Residential Development at 89 John Whiteway Drive, Gosford (SSD-10321)

Response to submissions

ATTACHMENT A – KEY ISSUES

1 WEST ELEVATION
DA009.10 1 : 200

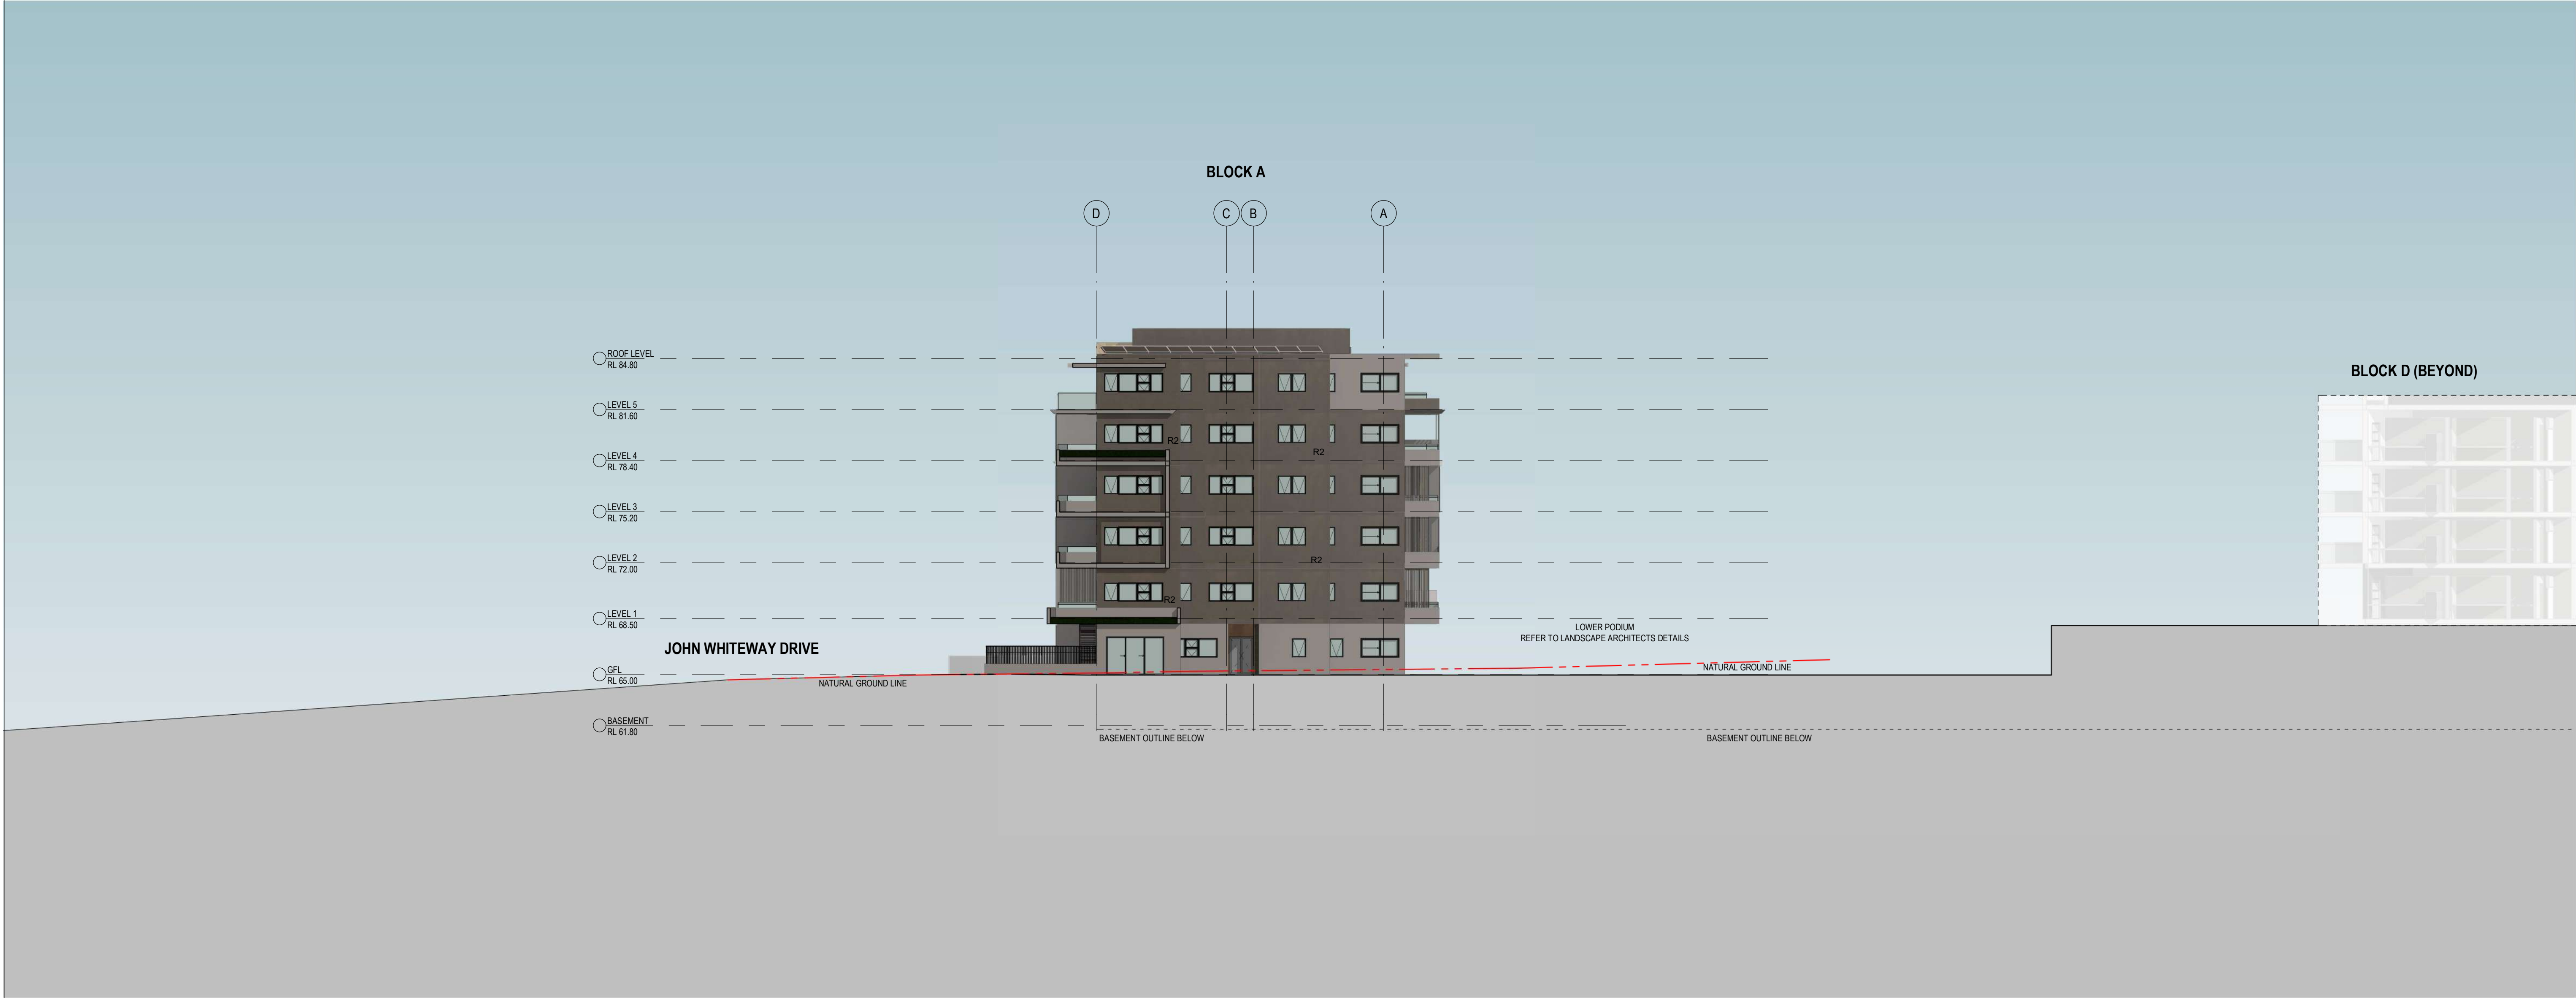
- Please provide sections, elevations and RLs on plans to demonstrate the visual quality and architectural treatment of the following sensitive interfaces:
 - The south eastern site interface (Block A)
The architectural plans (DA009.10 (Rev 10) and DA003.1 (Rev 11)) do not indicate the architectural character presented to the bushland corridor, the neighbouring site or public domain areas (on oblique angles).
 - The western and northern site interfaces (Blocks C and D)
The architectural character presented to the bushland corridor, and the amenity for lower-level units facing excavated areas and the bushland pathway should be shown.

SECTION FF  
SCALE 1:400 @A3

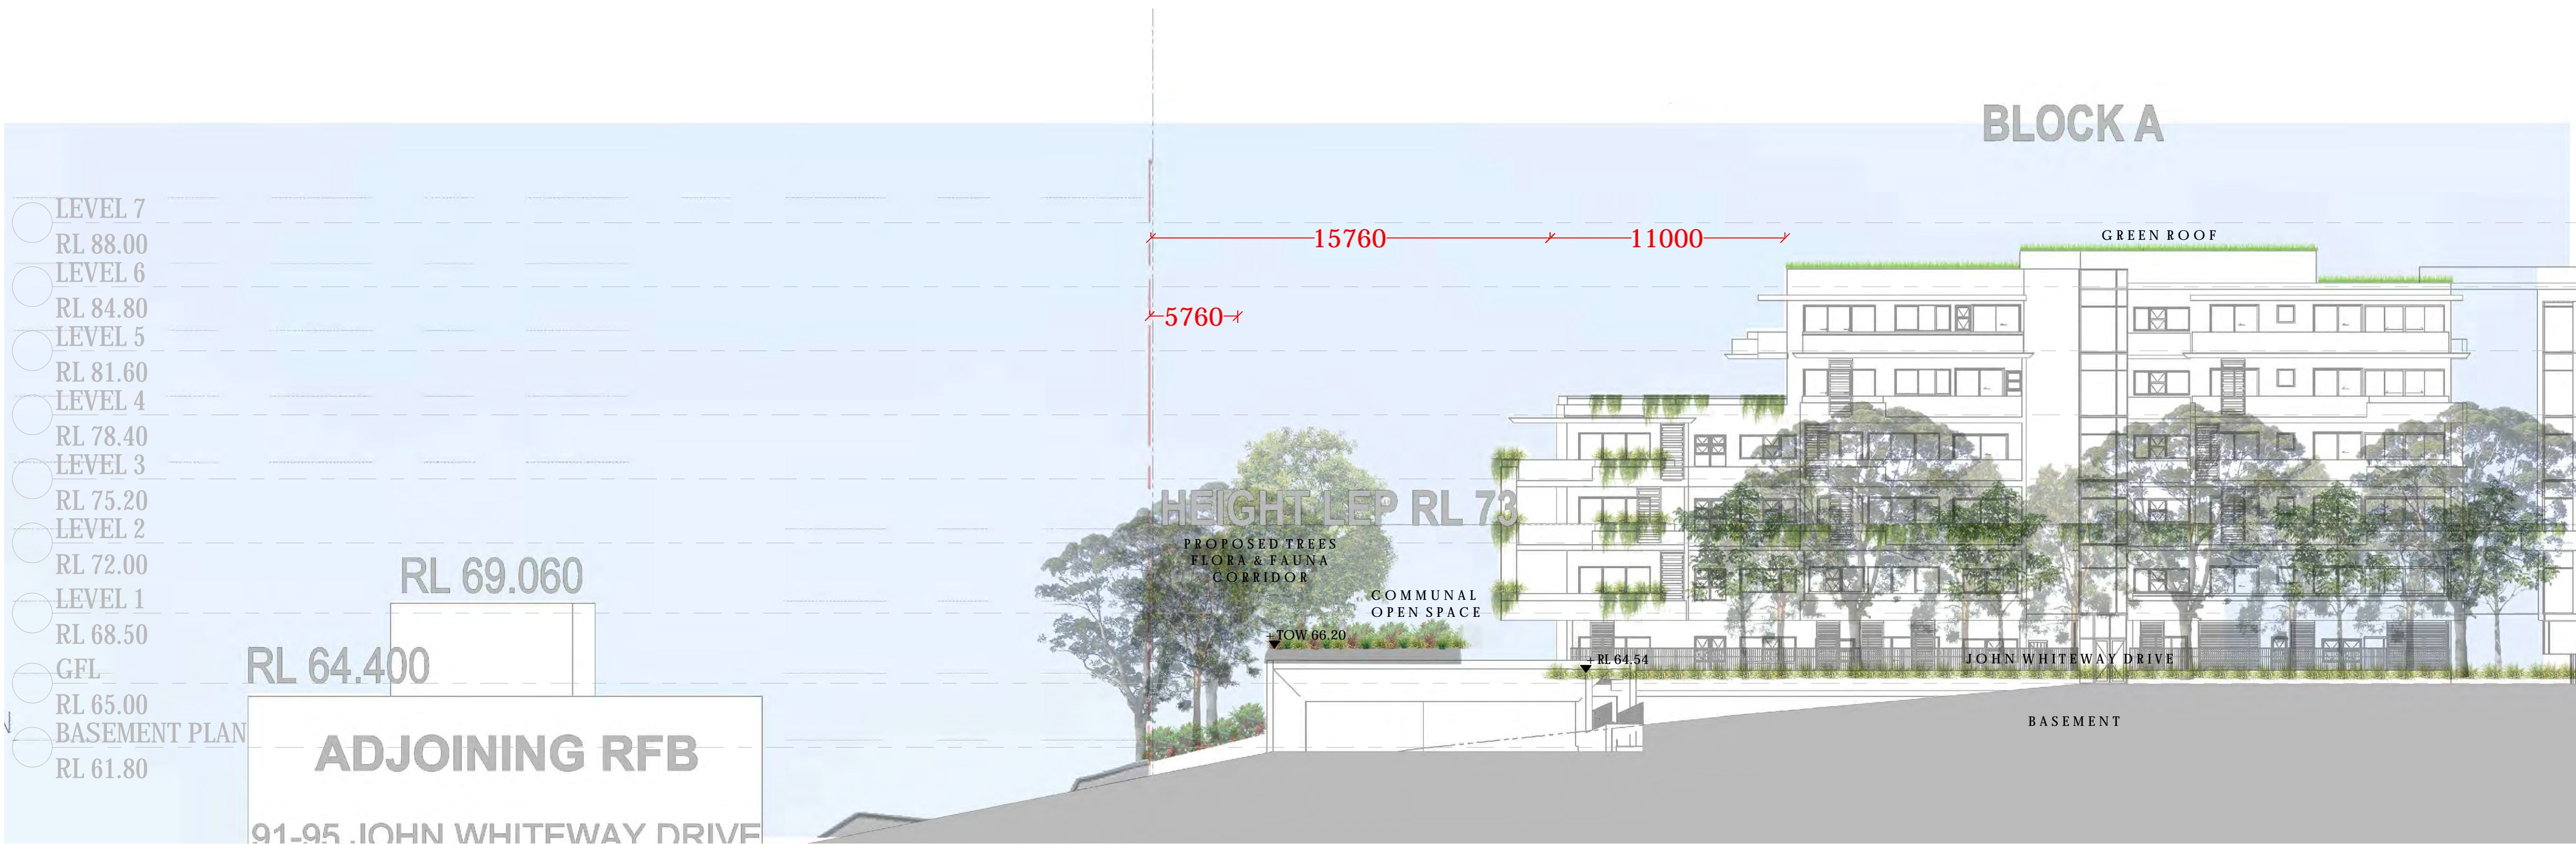
- Please clarify the exact location of the security gate at the south-eastern corner of the site near the basement entry, and how potential areas of concealment are prevented.
- Please clarify whether public access is available to the bushland corridor along the southern boundary.
- Please provide design solutions to soften the appearance of the protruding basement at the southeast corner of the site from John Whiteway Drive and neighbouring development, demonstrating capacity to meet Objective 3H-1.

Please clarify whether the public walkway and viewing platform are nominated as communal open space

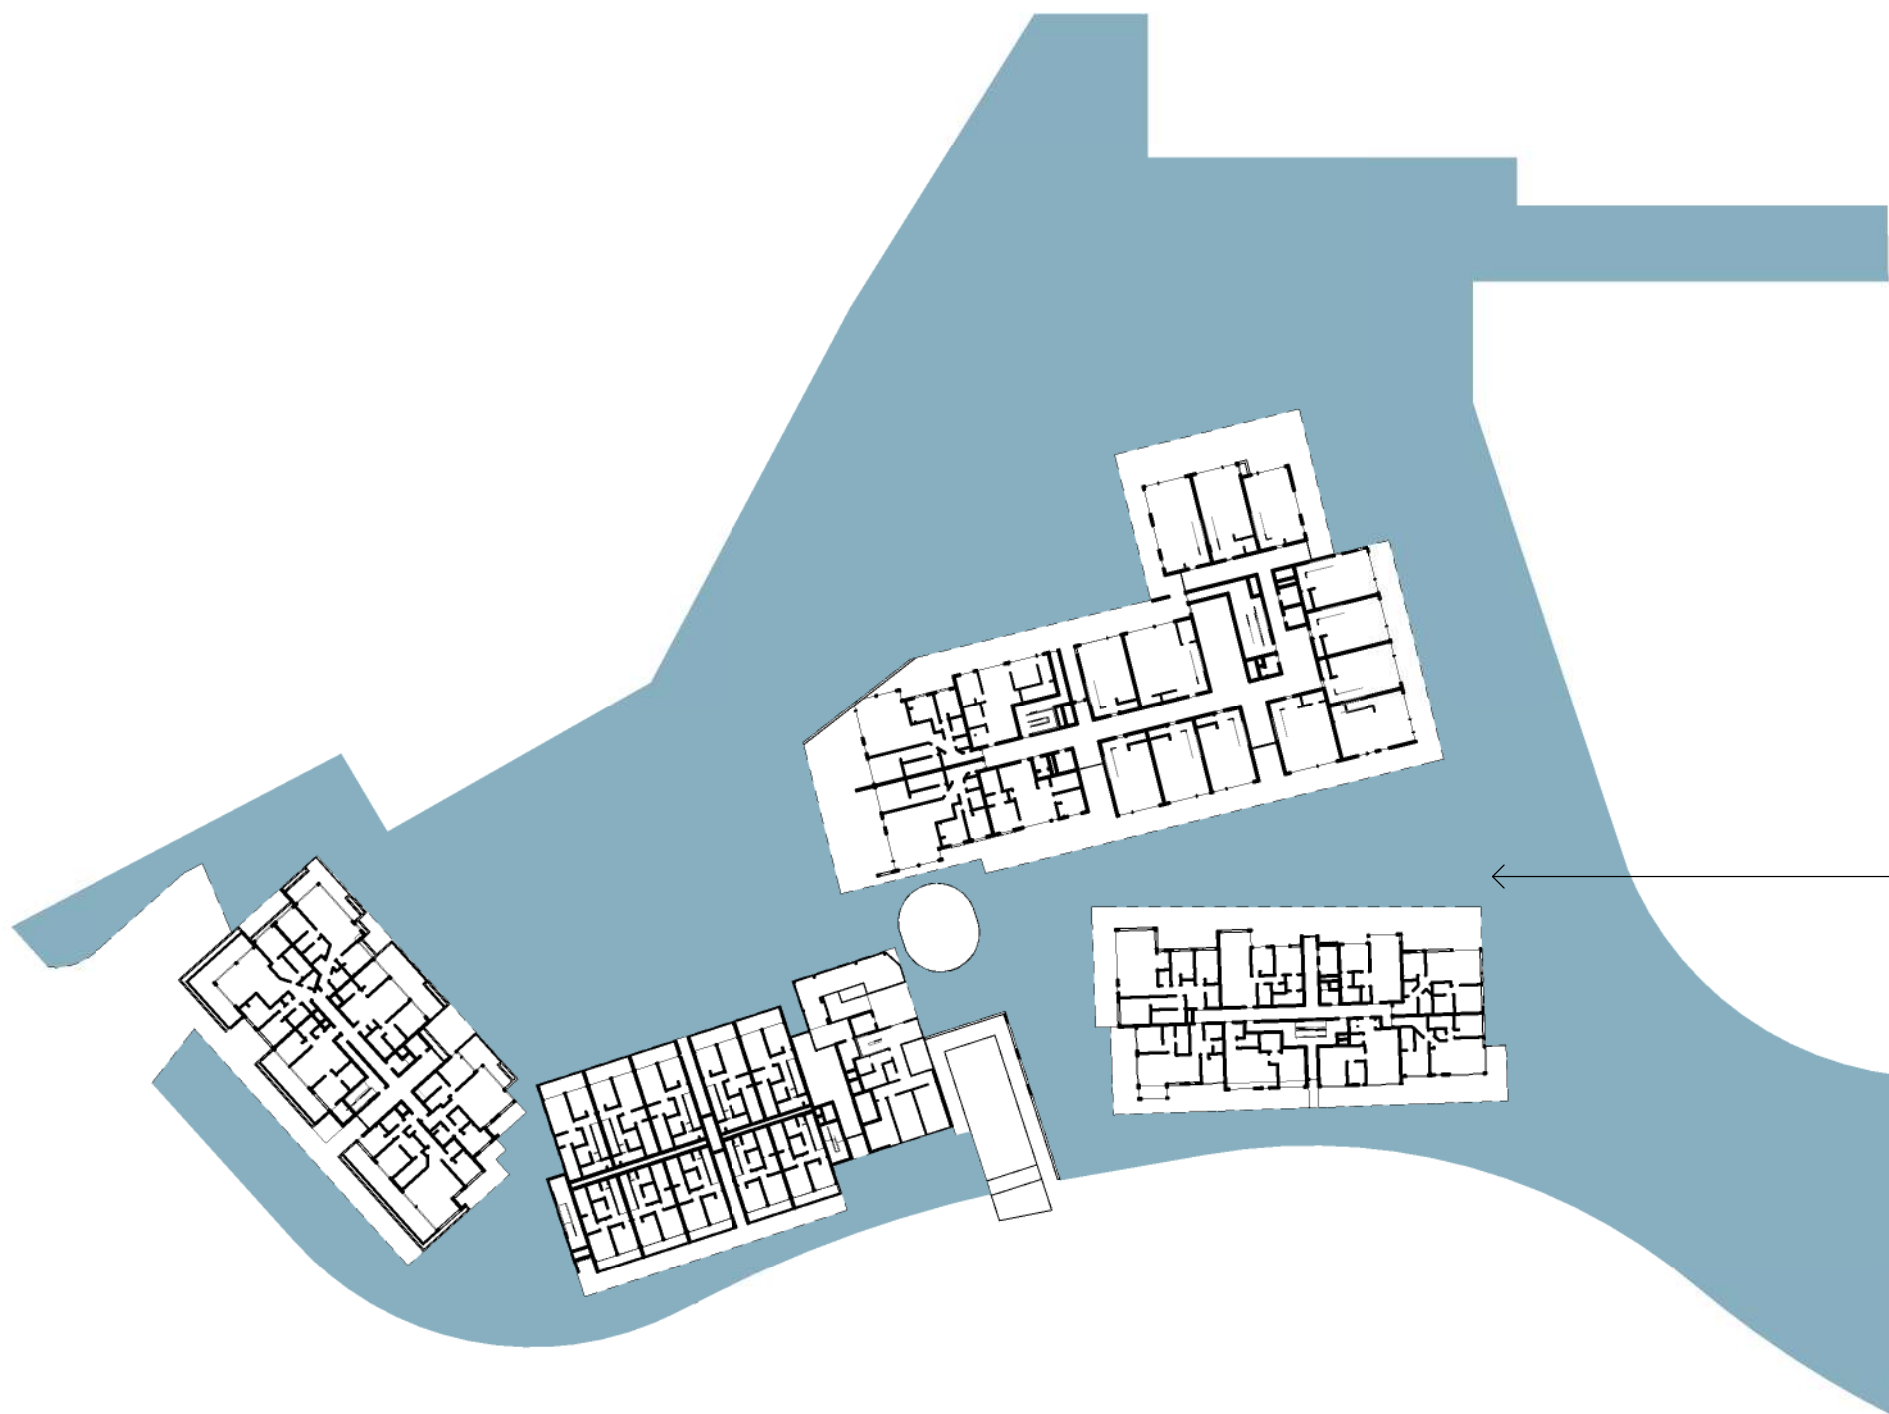
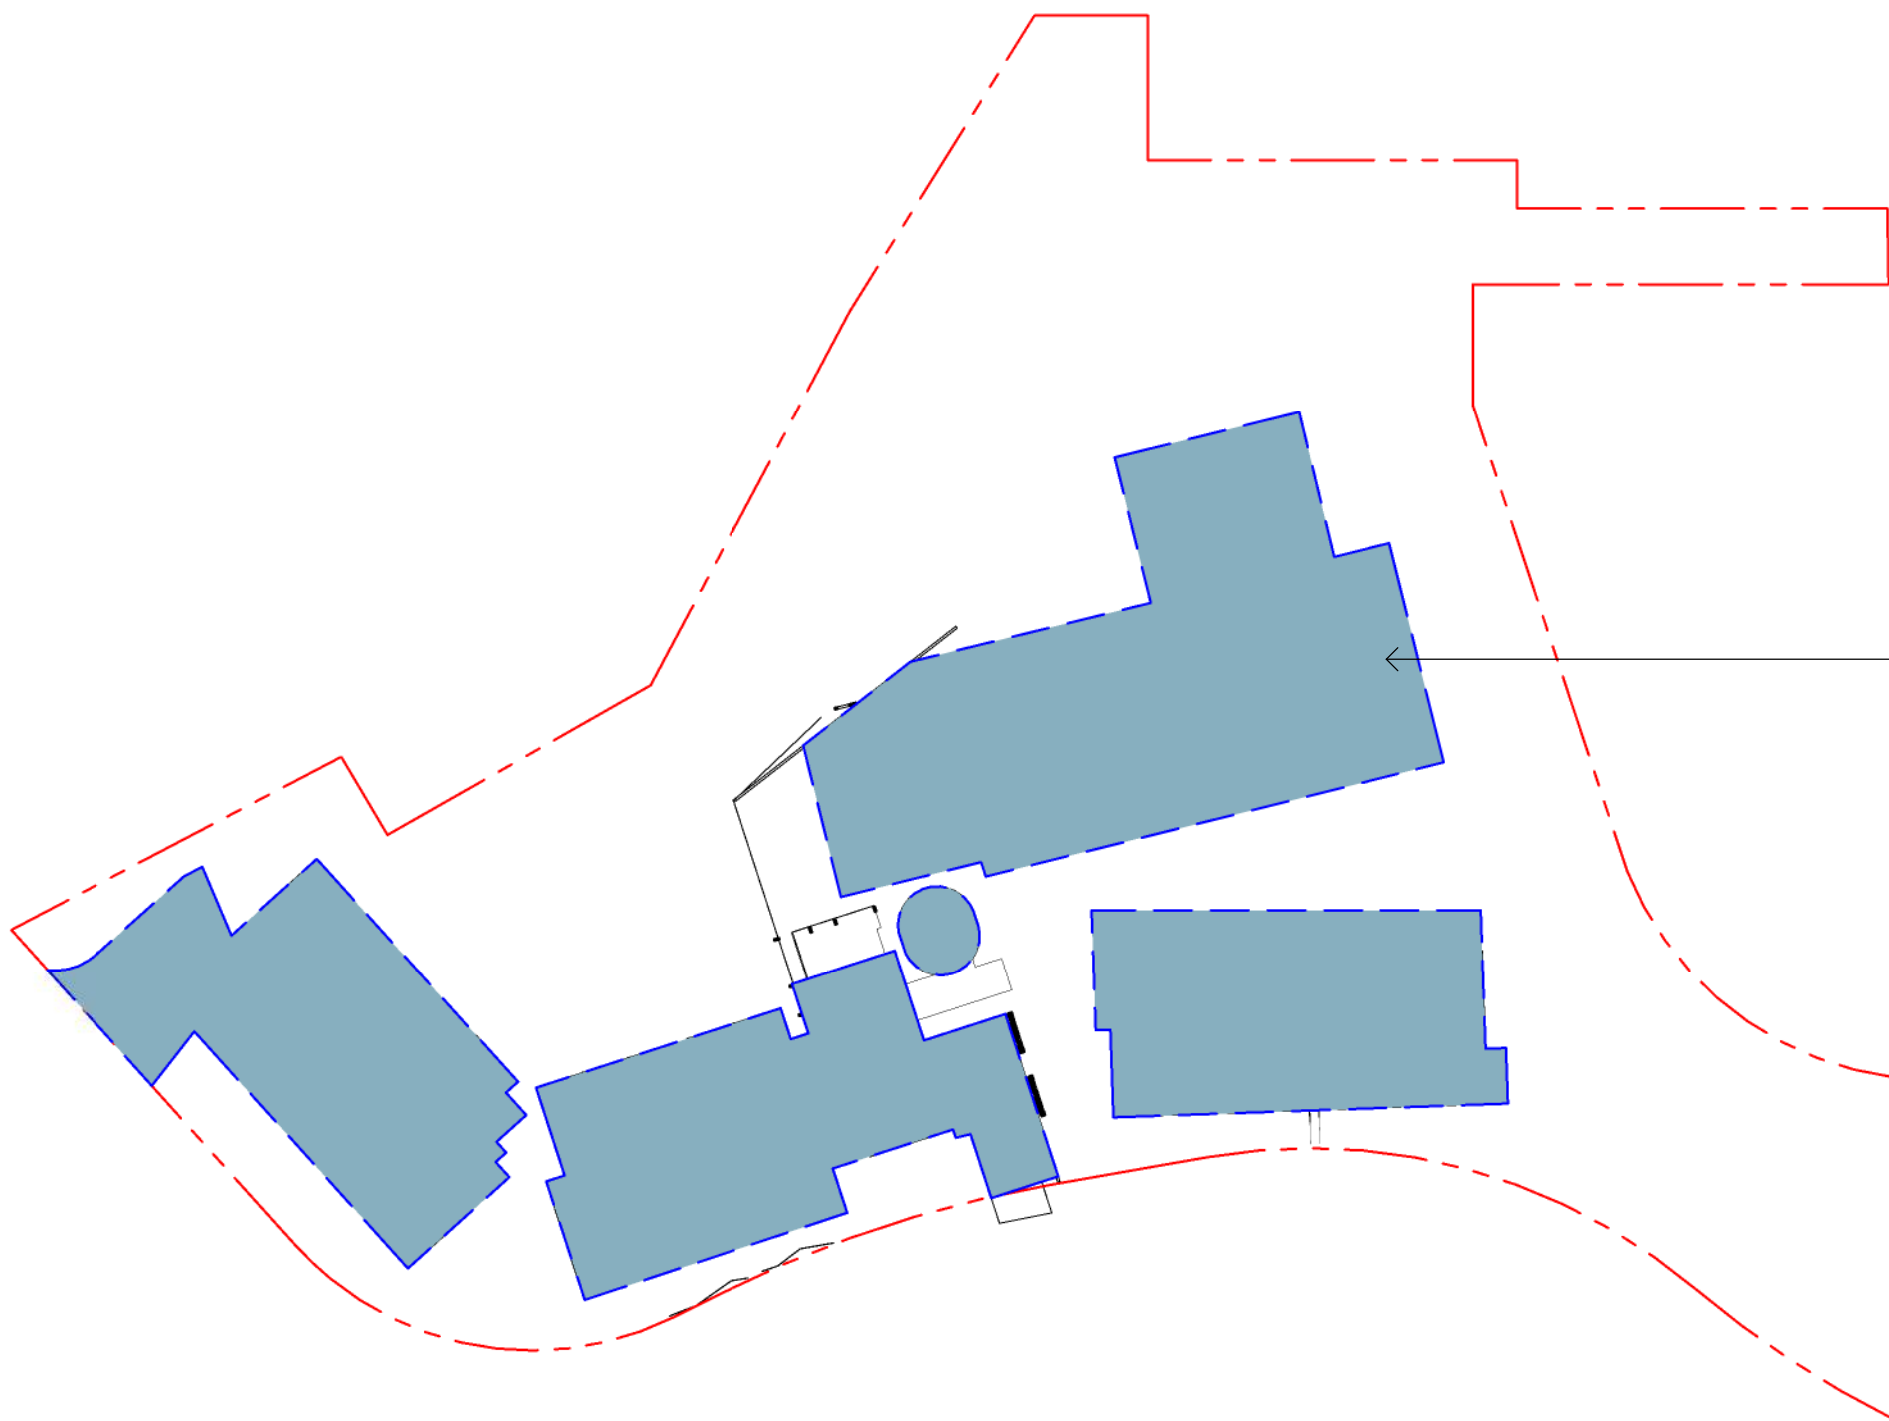
- Please clarify whether the public walkway and viewing platform are nominated as communal open space (Drawing No. DA001.4A).
- Please clarify access from the development to this walkway in the context of Objective 3D-3 of the ADG, as well as whether direct, equitable access can be achieved.
- Please clarify whether the areas highlighted in yellow (Drawing No. DA001.4B) are included in the calculation of communal open space in addition to the areas shown hatched.
